Recommendation Report for Works to Tree(s) on trees subject to a Tree Preservation Order (TPO)

REF NO: EP/43/20/T

LOCATION: Preston Hall, Timberley
The Street
East Preston
BN16 1HU

PROPOSAL: Fell 1 No. Lime tree

TREE WANTING
TO REMOVE
T1

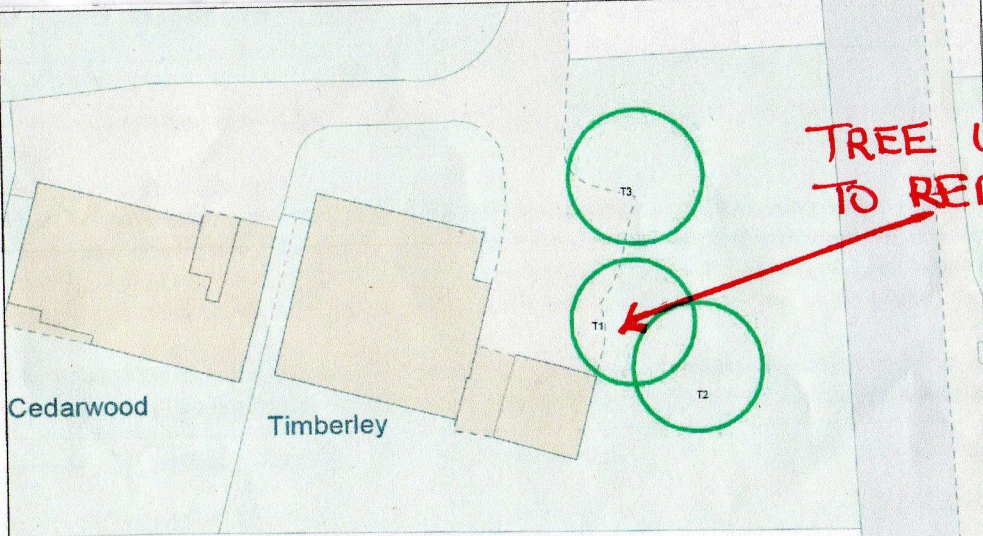
- It seems likely based on ground conditions, structures and anecdotal evidence described in the above report - substantial interference with soil structure/tree roots will have occurred. Although outwardly this tree appears to be in a fine physiological state, conflict and damage between it and built structures introduced within influencing-distance was inevitable - we have now arrived at situation which could reasonably be deemed intolerable for the occupier(s).

- The work proposed is justified on arboricultural grounds as the ongoing presence of T1 is not compatible with the continued use of garage extension and driveway restoration of any type.
- This is an unfortunate but necessary course of action. Although foreseeable, we must acknowledge the damage arising from the ongoing presence of the tree and sanction its removal - which can be mitigated with the planting of a suitable replacement tree in a more harmonious position on the plot.

- 1 Once the tree (T1) has been felled (and either grubbed or ground out) then a replacement tree is to be planted outside the crown spread of nearby trees to aid establishment and to within 15metres. This is to be of Standard Nursery Stock proportions (10-12cm girth & 2m to 3m overall height) supported on a 'short stake' system with appropriate securing ties and pads. It is to be planted within 12 months of the removal of the lime tree (T1).
